Re: Dialogue Brewery - 1501 1st NW; Bldg Permit #201691052
Request for Certificate of Occupancy- Transportation Development
Architect's Stamp dated 05-18-16 (J14D040A)
Certification dated 10-25-16

Based upon the information provided in your submittal received 10-27-16, Transportation Development has no objection to the issuance of a Permanent Certificate of Occupancy. This letter serves as a "green tag" from Transportation Development for a Permanent Certificate of Occupancy to be issued by the Building and Safety Division.

Re: Dialogue Brewery
1501 1st NW; Bldg Permit #201691052
30-Day Temporary Certificate of Occupancy- Transportation Development
Architect's Stamp dated 05-18-16 (J14D040A)
Certification dated 09-22-16

Re: Dialogue Brewery
1501 1st NW
Traffic Circulation Layout
Engineer's/Architect's Stamp dated 5-18-16 (J14-D040A)

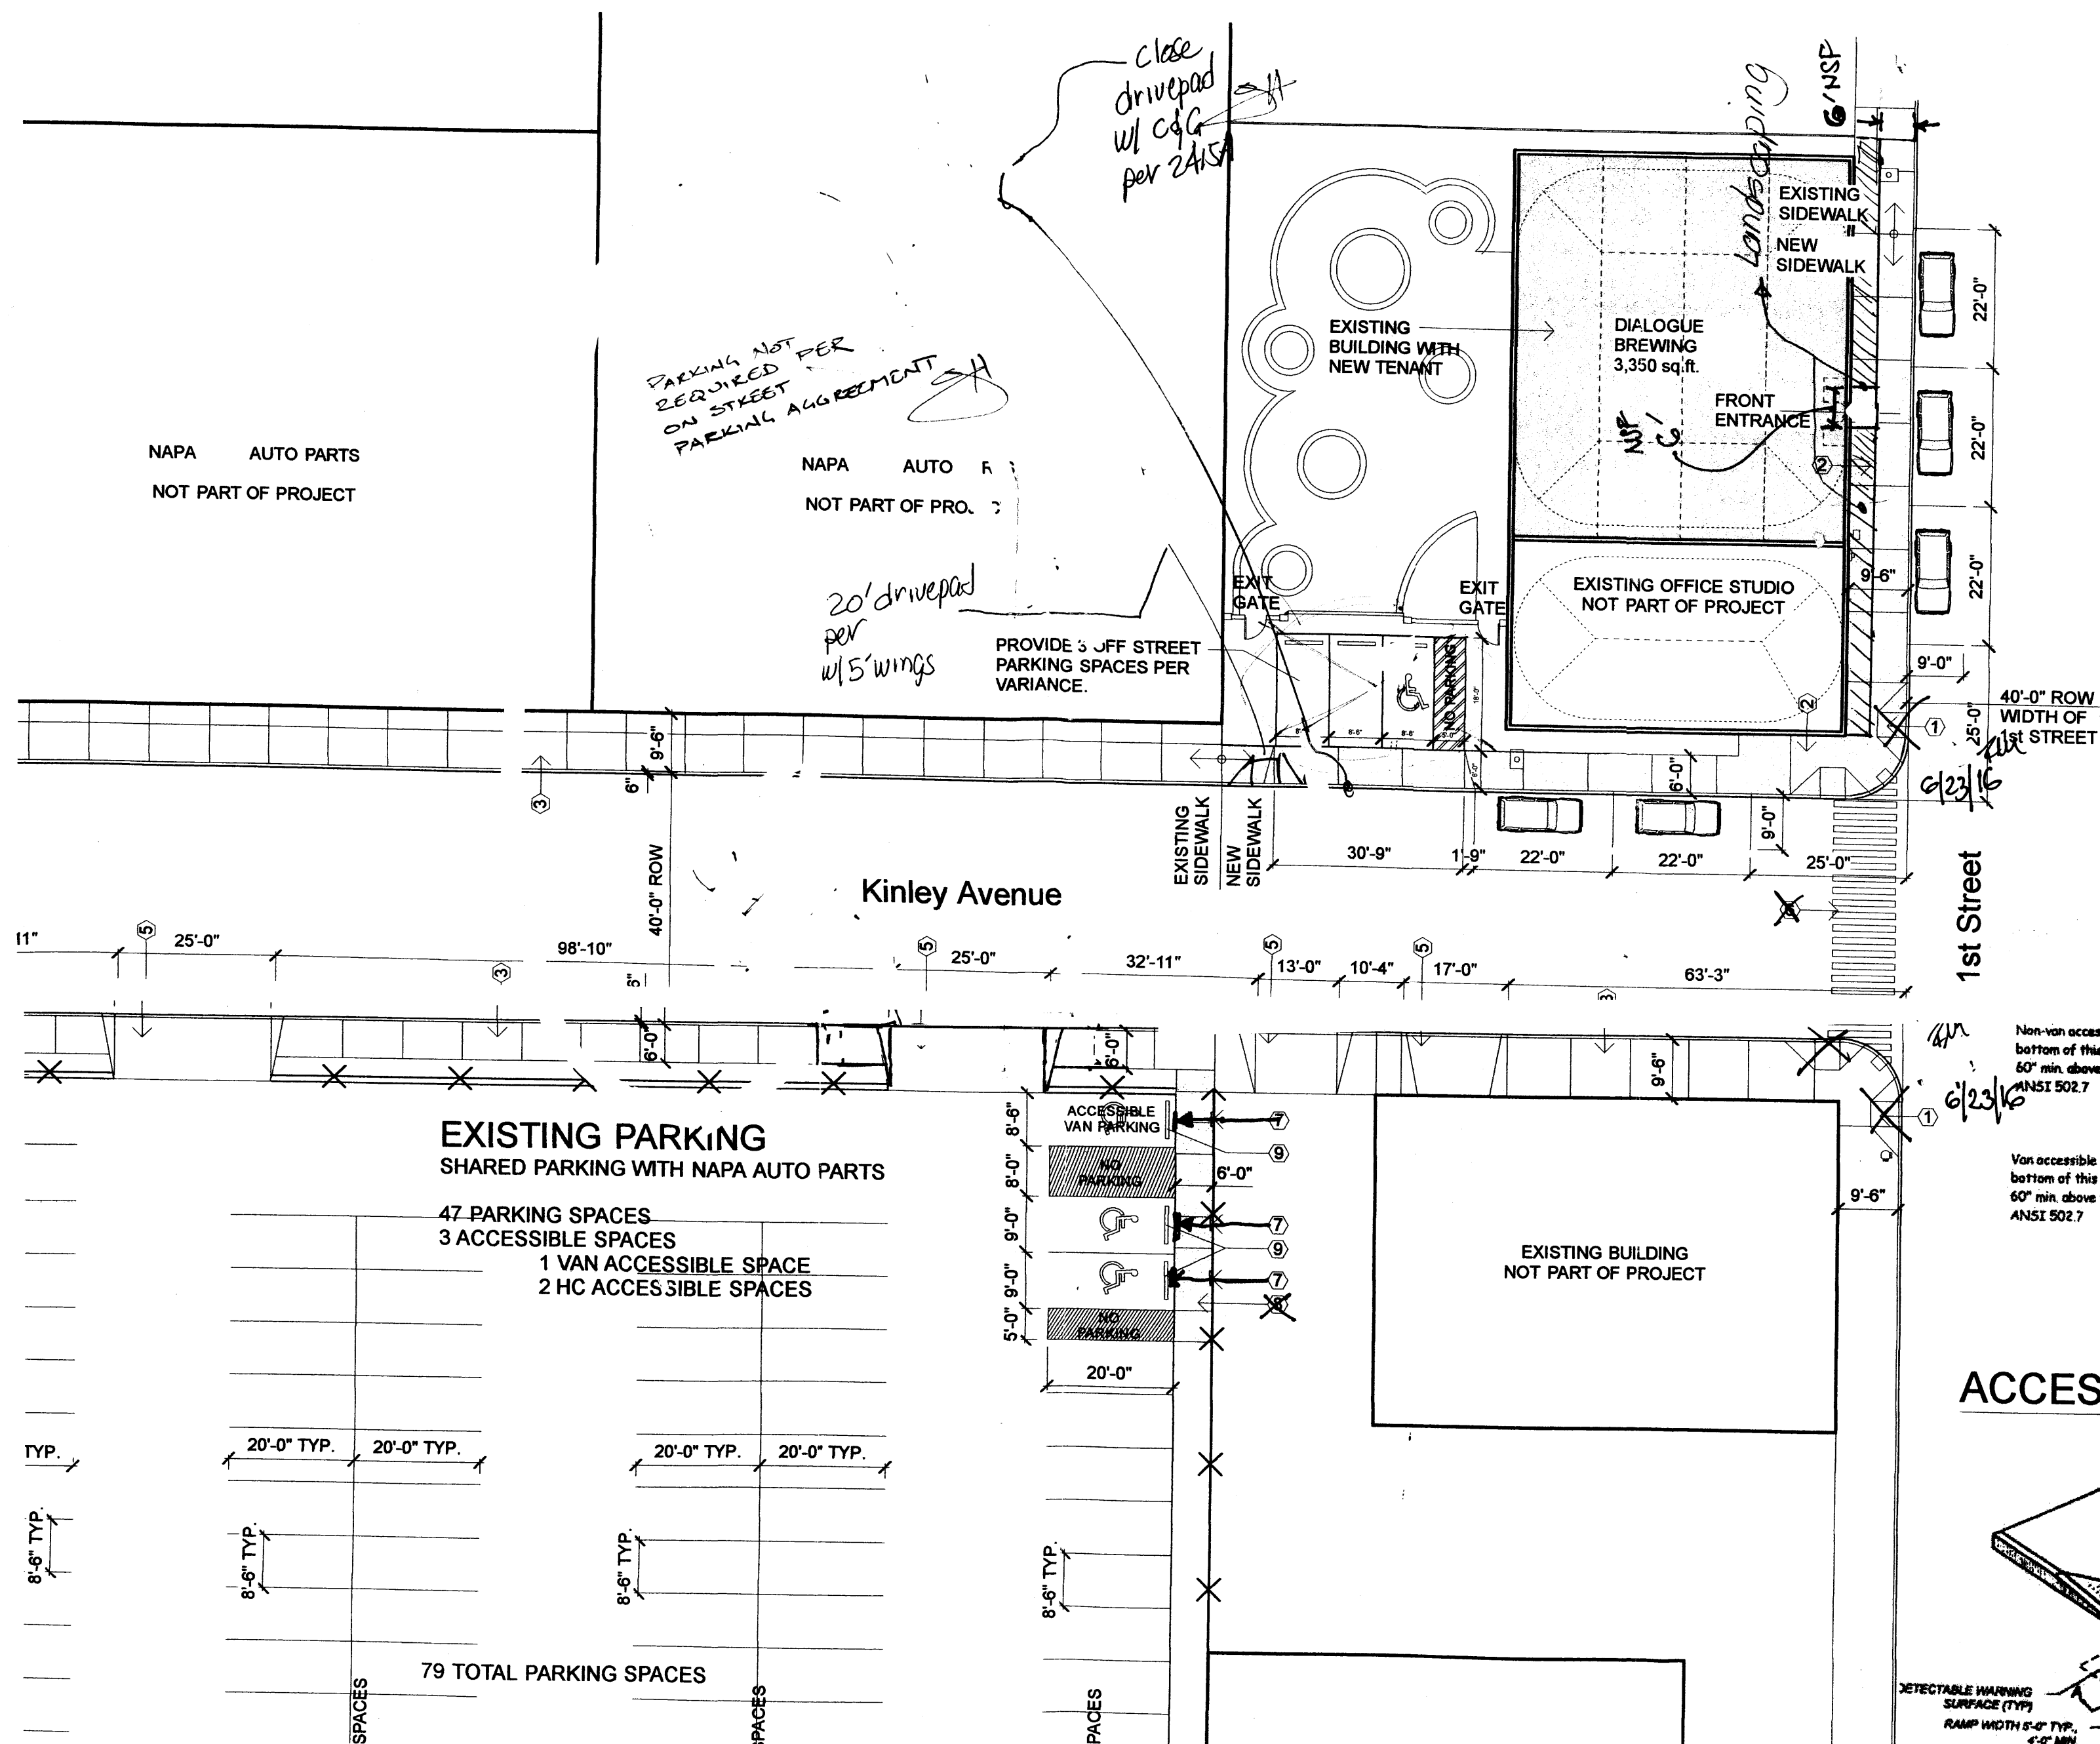
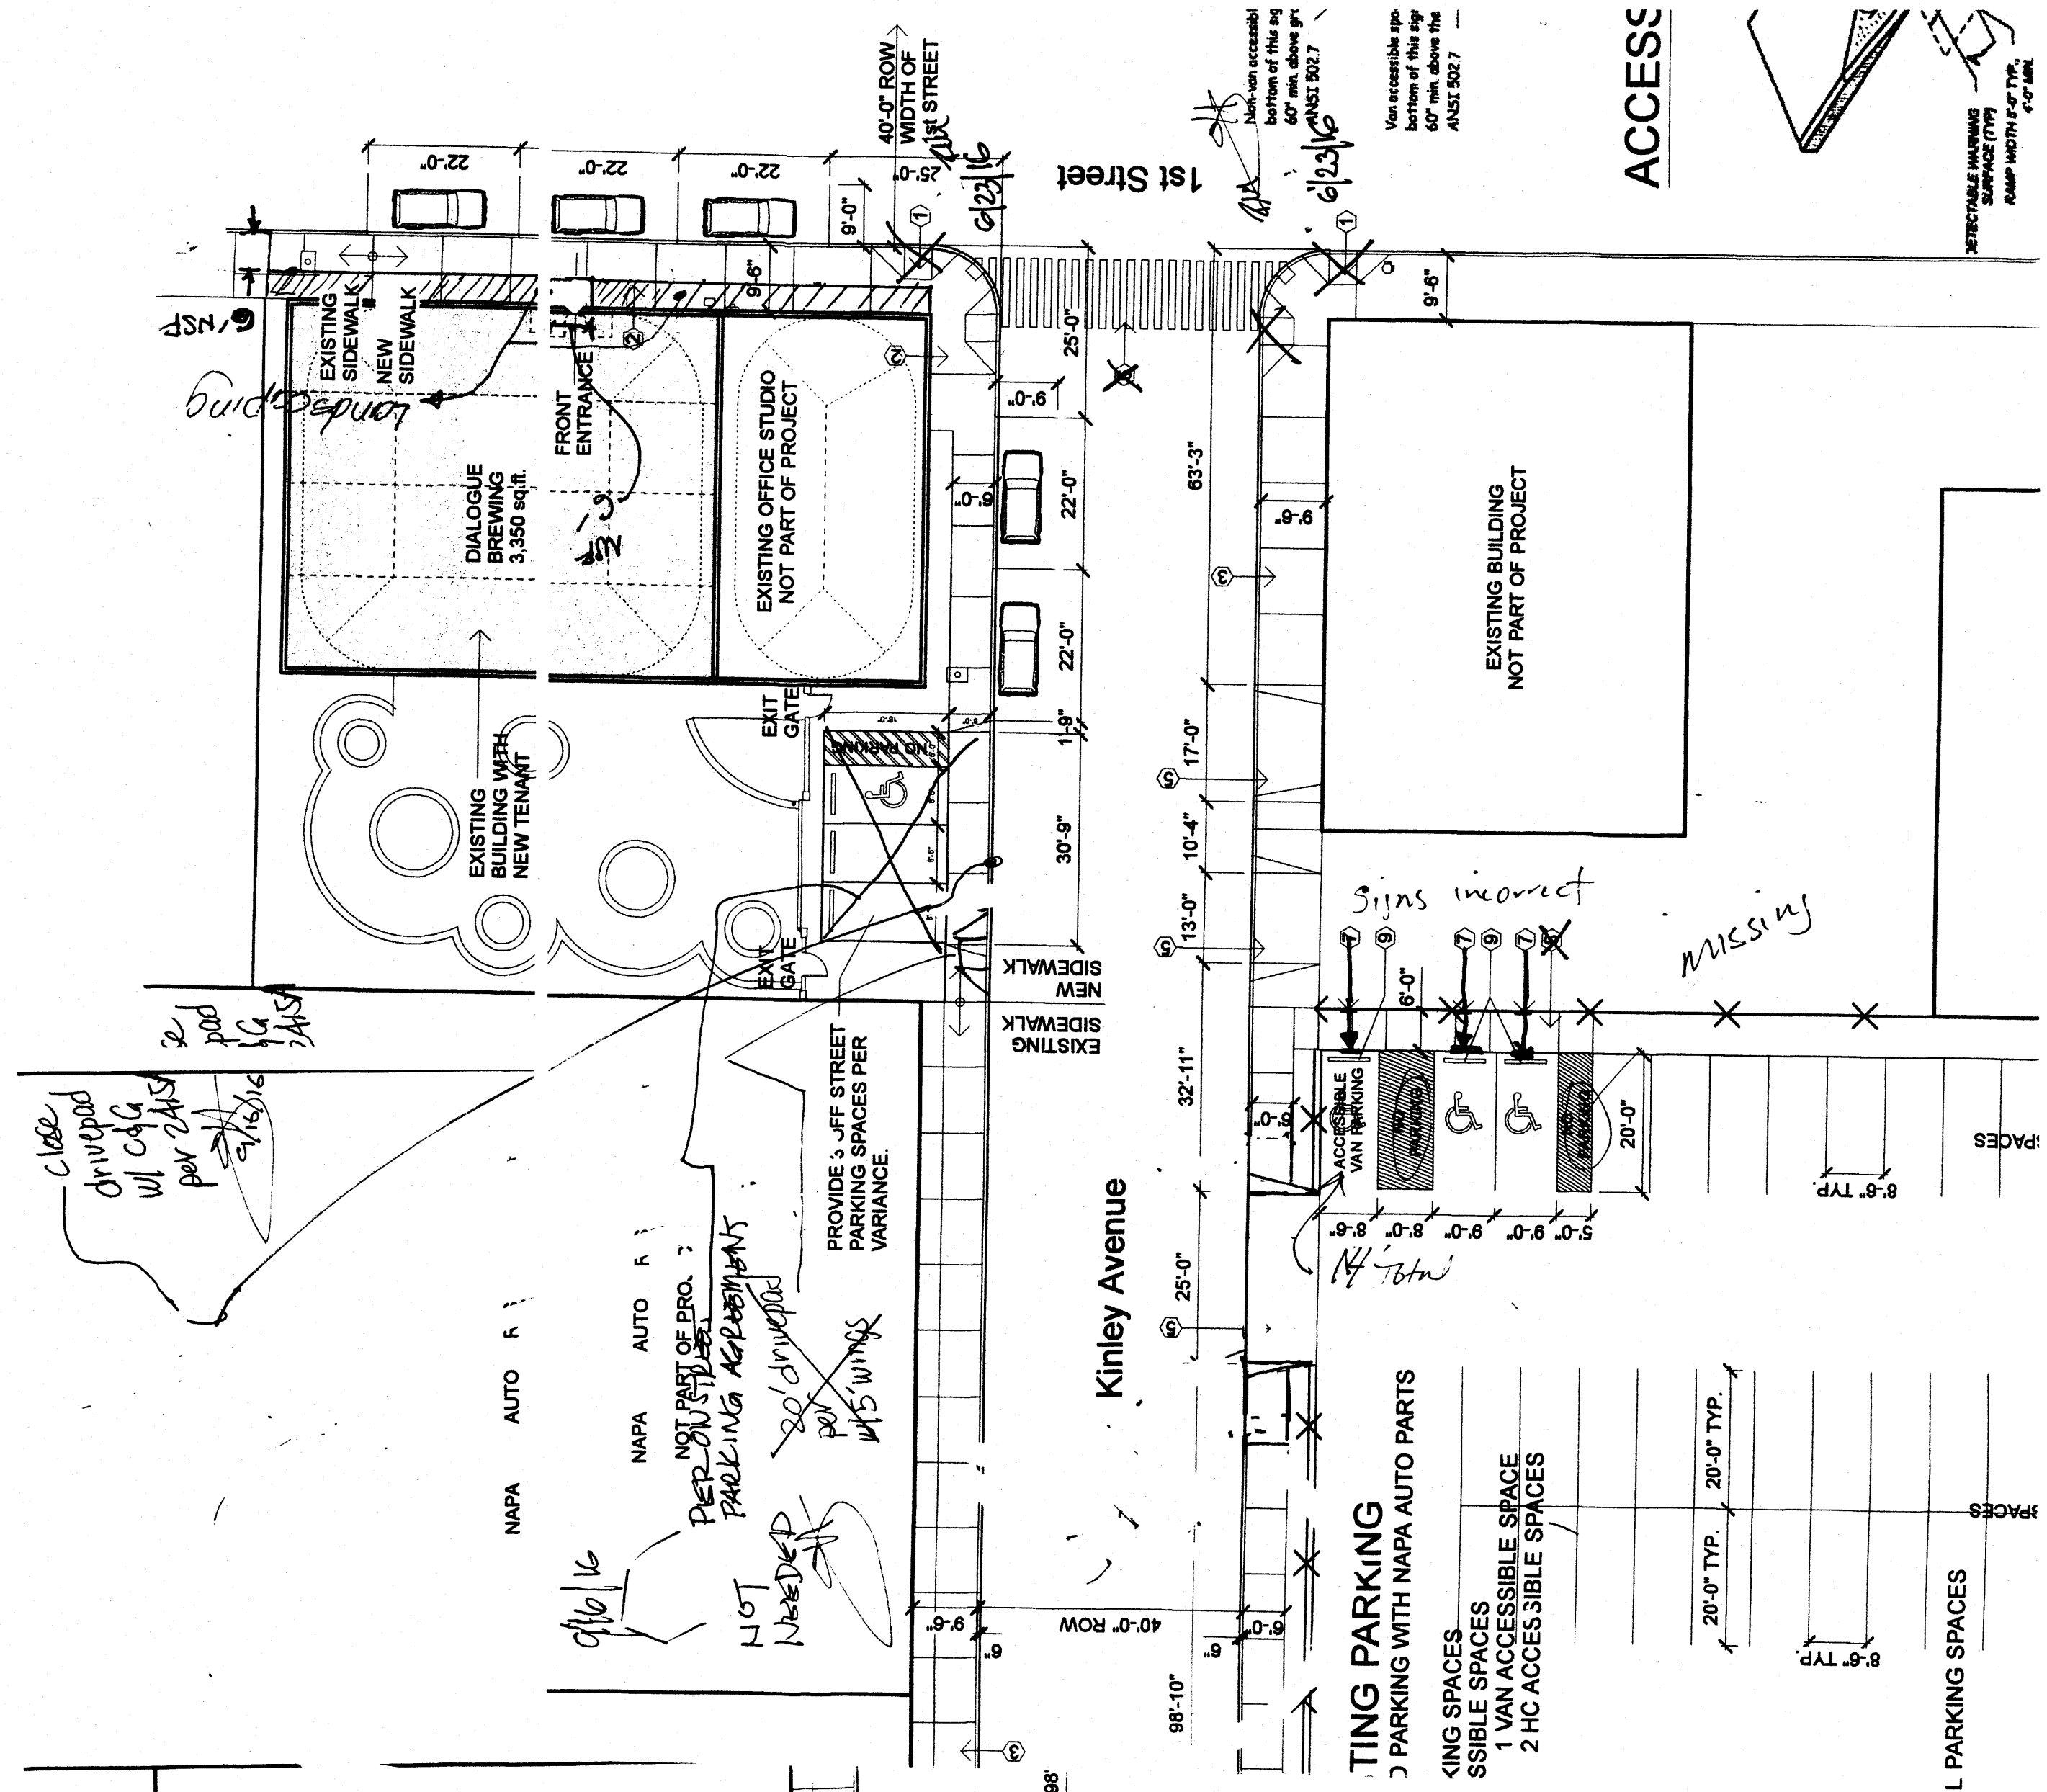
Prior to the issuance of a permanent Certificate of Occupancy, the following items must be addressed:

1. The handicap accessible spaces must be a minimum of 8.5 ft. in width.
2. The handicap accessible spaces must include an access aisle. Van accessible aisles should be 8ft wide; all others should be 5ft wide.
3. The ADA accessible parking sign must have the required language per 66-7-352.4C NMSA 1978 **"Violators Are Subject to a Fine and/or Towing."** Please call out detail and location of HC signs.
4. The ADA access aisles shall have the words **"NO PARKING"** in capital letters, each of which shall be at least one foot high and at least two inches wide, placed at the rear of the parking space so as to be close to where an adjacent vehicle's rear tire would be placed. (66-1-4.1.B NMSA 1978)

- **On-Street parking credit must be secured and the three parking spaces located on the south west corner of the site must be removed.**
- **The driveway providing access to those spaces must be replaced with standard curb, gutter and sidewalk.**

The City inspector visited the site and noted that the accessible parking spaces needed to be widened, that NO PARKING be labeled in side loading zones adjacent to accessible parking spaces and that the ADA signage be corrected. I have visited the site and certify that these corrective measures have been completed.
